RE: Hyak Amended Planned Unit Development Final Development Plan Addendum

As a result of meeting with you and staff reviewing the CDS Letter dated January 19, 2018, we would like to add this addendum to the original Hyak Amended Planned Unit Development (PUD) Final Development Plan submittal. Please accept this narrative, in accordance with your letter dated January 19, 2018 meeting the requirements in order to obtain final development plan approval.

EX-1 SHEET

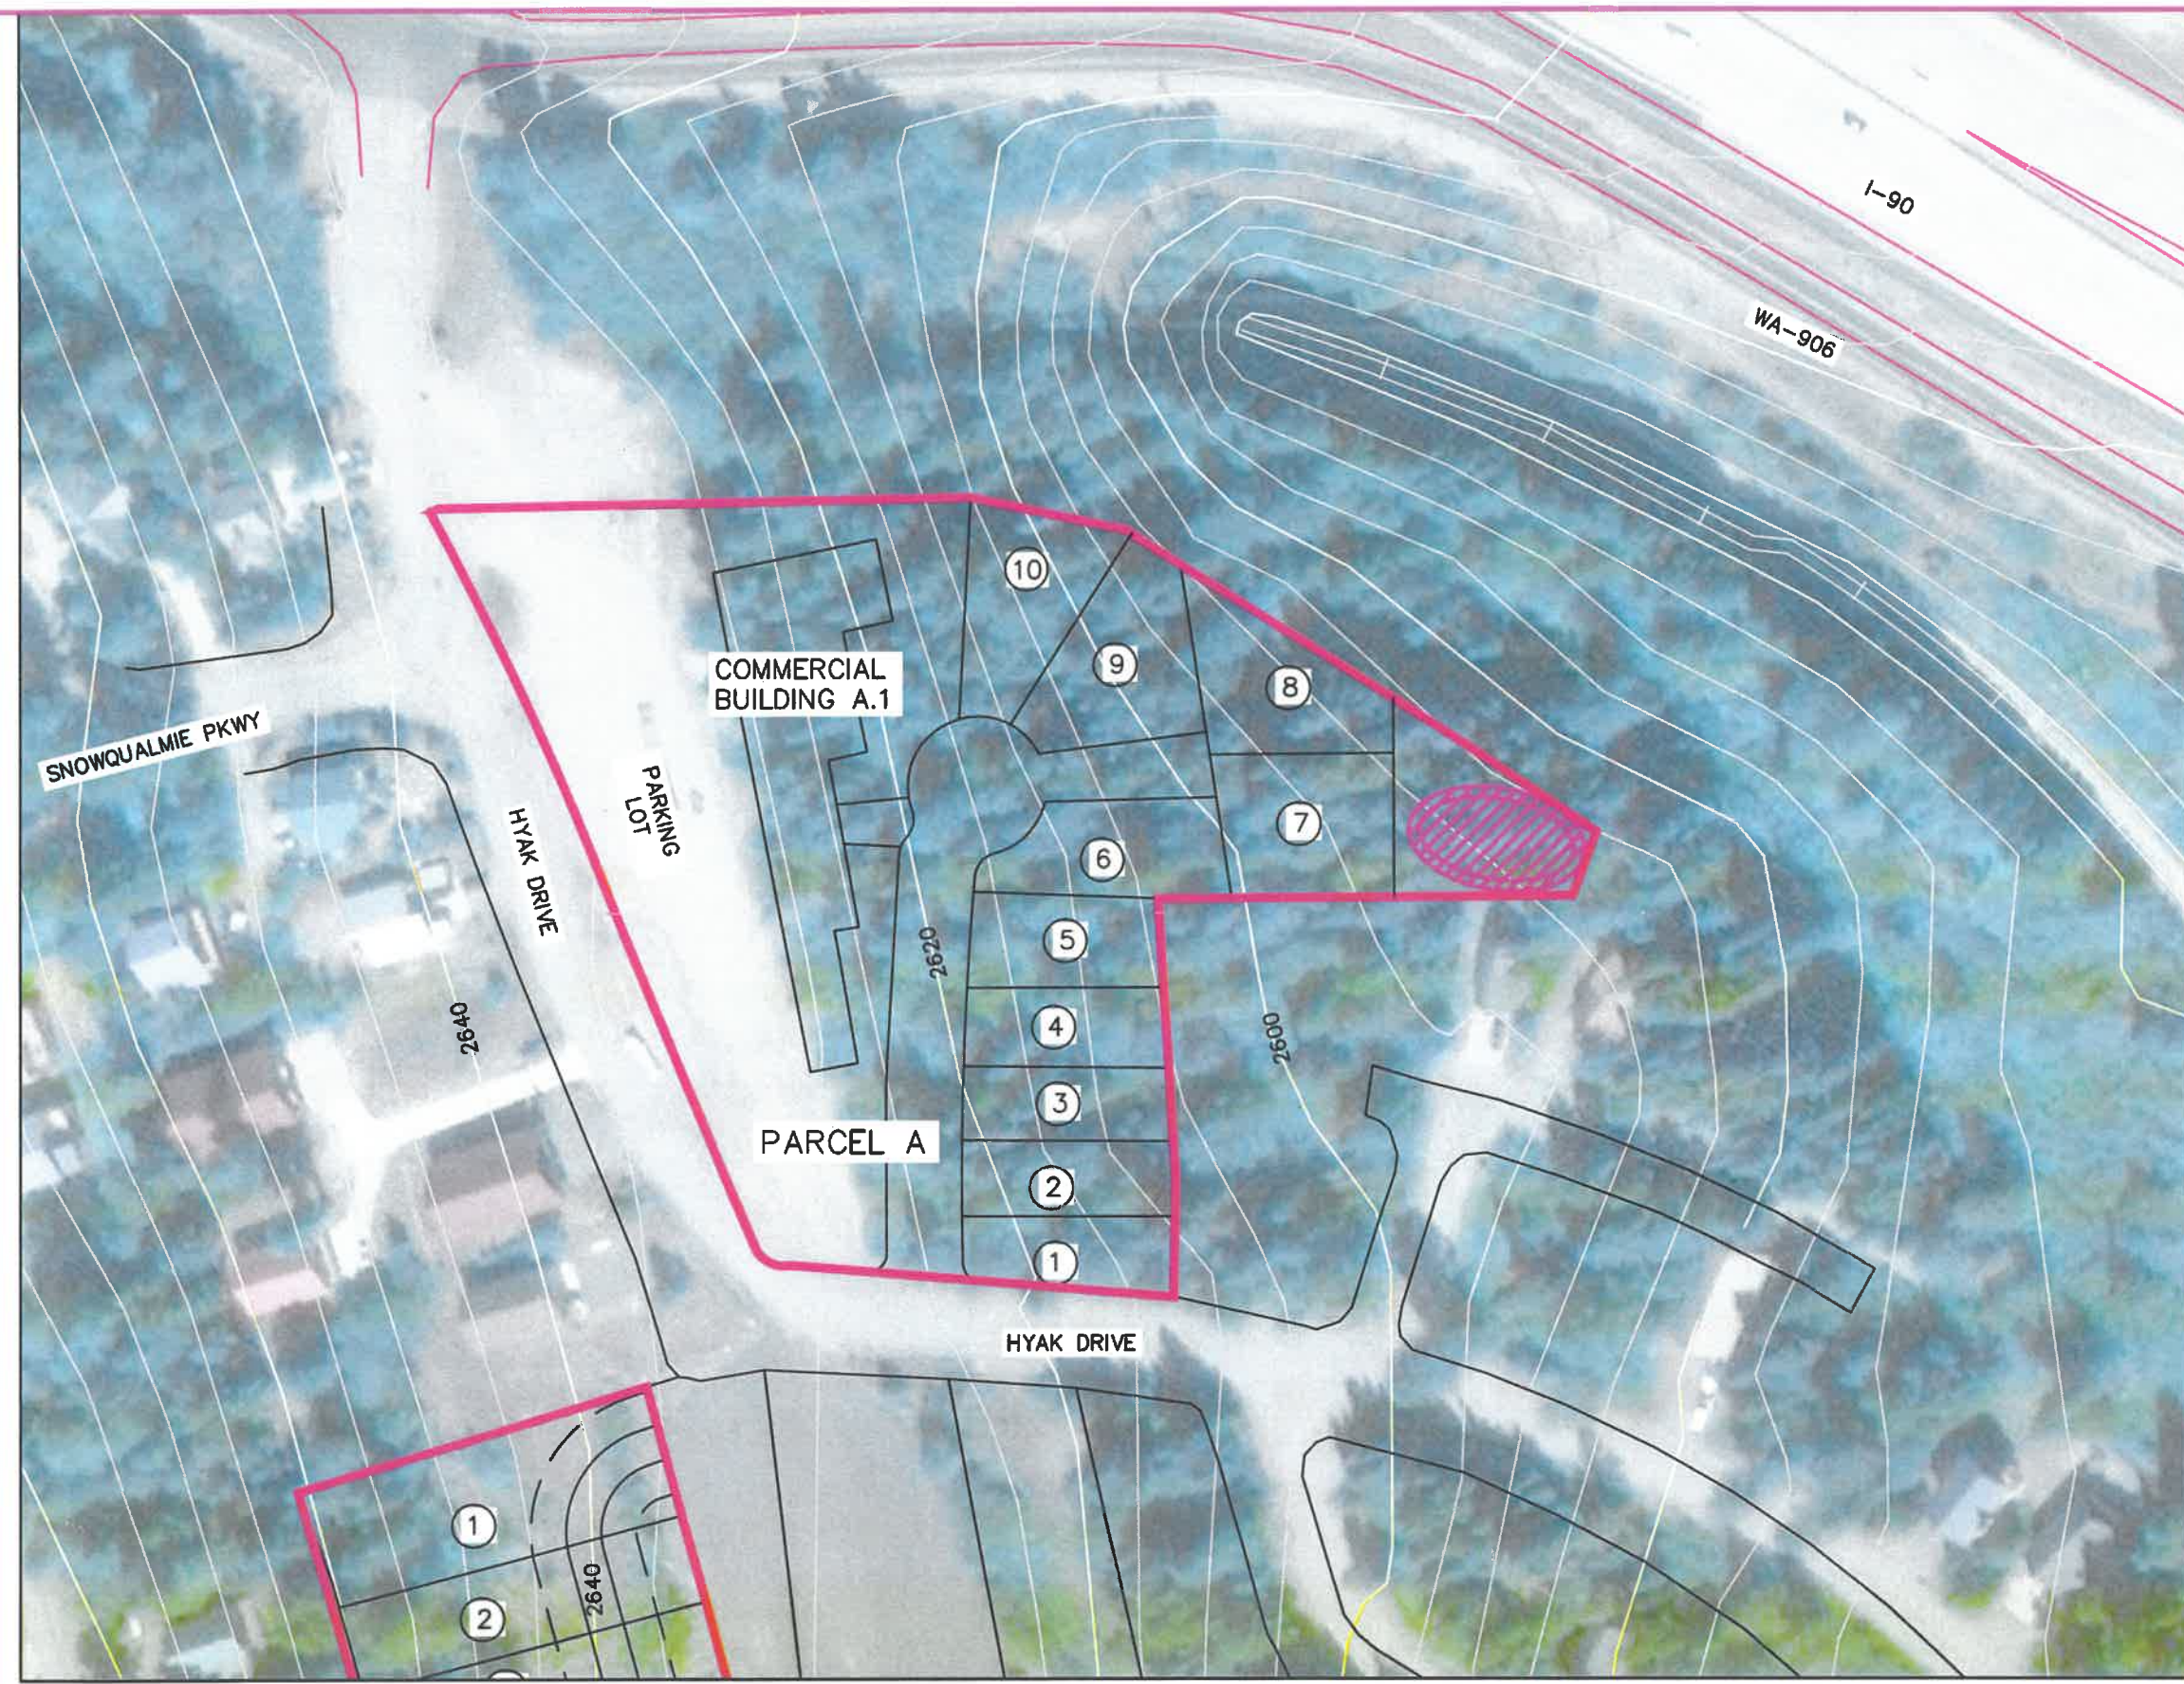
Section A.2, viii. Pubic works memo calls stormwater out as a potential issue, for the purpose of the FDP applicant shall provide a conceptual stormwater plan with shall include detailed contour information. Using strowmater facilities for snow storage are also a concern.

Section B.4 Per Public works memo and project narrative, final site grading and contour map; this shall be addressed prior to final plat. A contour map is necessary prior to FDP approval.

Section B.13 The application provides for 1 parking space per condo unit needs to be 1.5 per unit a minimum per approval condition and Public Works memo.

Response: We have included the contour information and overlaid onto the larger scale maps providing more detailed information per the Kittitas County Department of Public Works memo. It is also understood that this initial proposal is for final development plan approval and once final divisions are proposed then a detailed stormwater design/plan will be submitted for review and approval including but not limited to snow storage scenarios. See Addendum Attachment A & B.

Response: We have included the contour information and overlaid onto the larger scale maps providing more detailed information per the Kittitas County Department of Public Works memo. Once final divisions are proposed then a detailed site grading design/plan will be submitted for review and approval. See Addendum Attachment A & B

Response: We have address the parking requirement by revising the parking tables to account for 1.5 parking spaces per multifamily unit (condominiums and duplexes). See Addendum Attachment D., EX-1 through 4.

**EX-3
 SHEET**

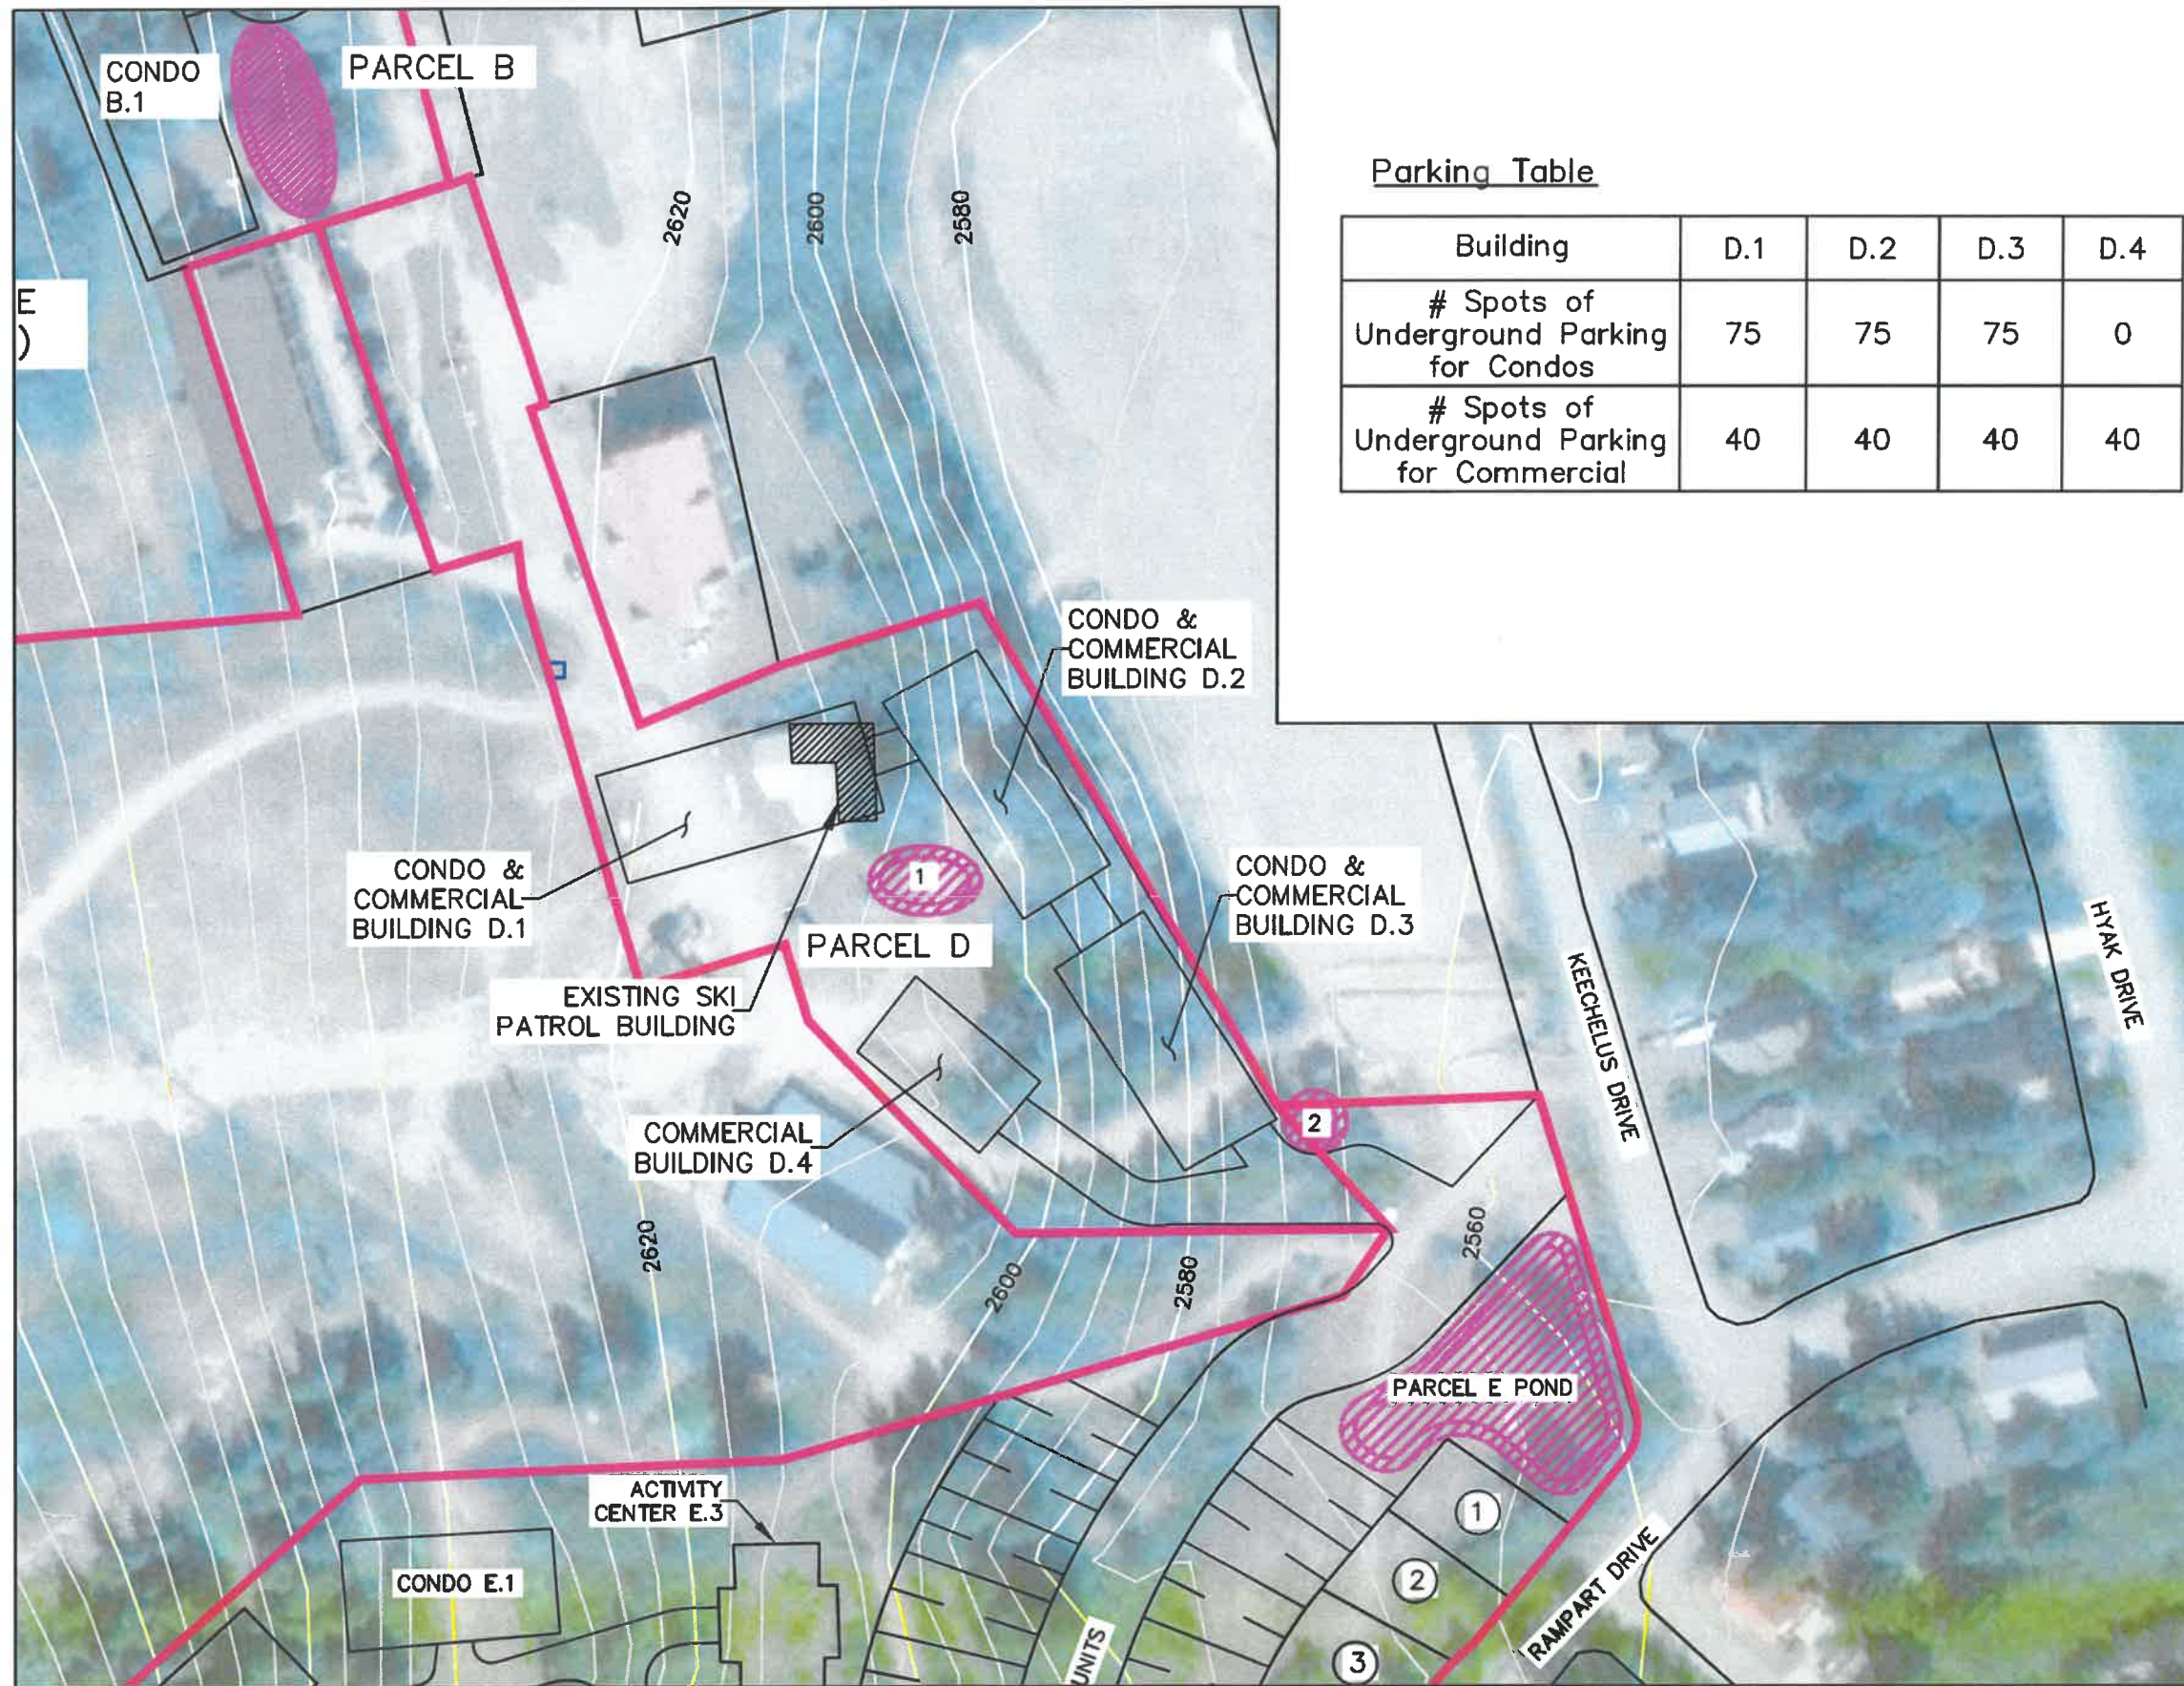
In addressing the commercial space, per Encompass Engineering, the County Public Works Department referenced ITE 7th edition. Per part 3 of their letter regarding commercial space, they appear to be referencing code 870 for apparel stores at 4 trips per peak hour per 1,000-sq.ft. (rounding up from 3.83 trips). The tables have been revised to account for the 4 trips per peak hour per 1,000-sq.ft.

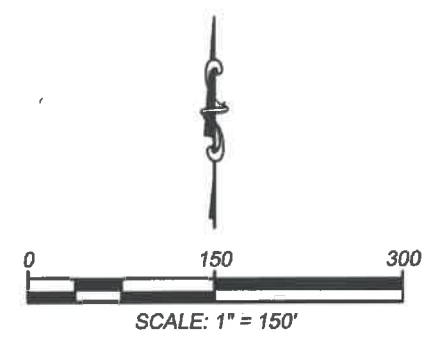
In addressing the Activity Center Parking, per Encompass engineering, The County's reference to code 435 seems somewhat arbitrary given the units to measure for those parking requirements are in acres as opposed to per 1,000-sq.ft. We are trying to understand the suggestion of "as many as 90 weekday trips based on land use code 435" per their letter. In Encompass's re-assessment of the land use codes, we thought that Code 495 that is identified specifically for a recreational community center potentially made more sense but resulted in a requirement of only 10 parking spots. For now we used the same requirements for the activity center that were used for

commercial space resulting in 24 parking spots instead of the 20 spots we had previously shown.
